# KITTITAS COUNTY DEPARTMENT OF PUBLIC WORKS

## MEMORANDUM

TO: Mackenzie Moynihan, CDS  
FROM: Christina Wollman, Planner II *cw*  
DATE: June 20, 2008  
SUBJECT: B&J Plat LP-08-21

B & J PLAT
PART OF SECTION 7, T. 17 N., R. 18 E., W.M.
KITTITAS COUNTY, WASHINGTON
- PRELIMINARY PLAT -

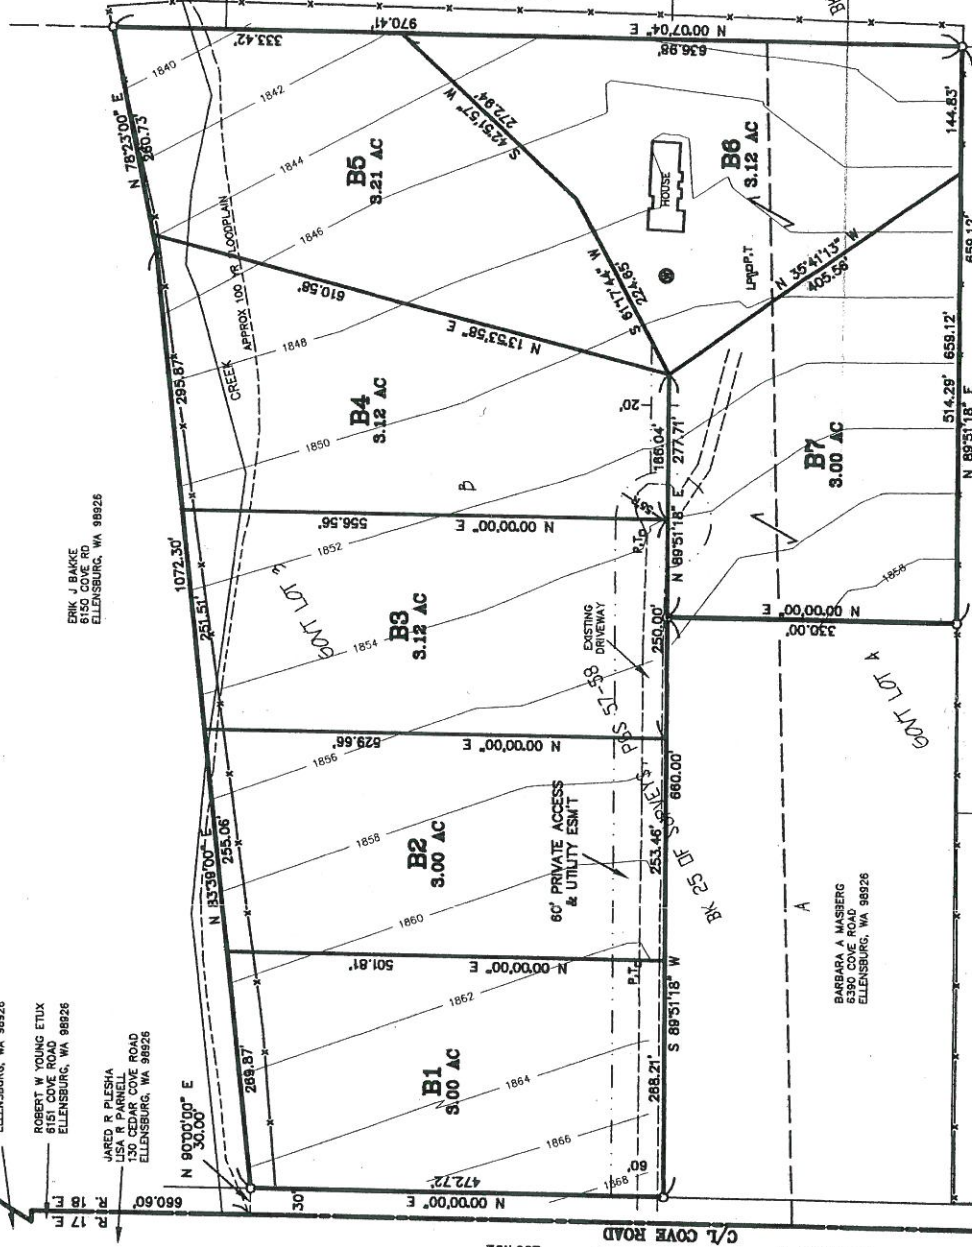
Kittitas County Road Standards require accesses onto Cove Road to be spaced 1000 ft apart (Chapter 5, Table 5-1). The change in use of the single-use access to a private road serving 7 lots enacts this requirement. Currently, the access is located approximately 550 ft from the access to the north, and 240' from the access to the south. The applicant may apply for a variance through the Public Works Department to allow the access spacing requirement to be reduced. Conditional preliminary approval will not be granted until the variance is approved.
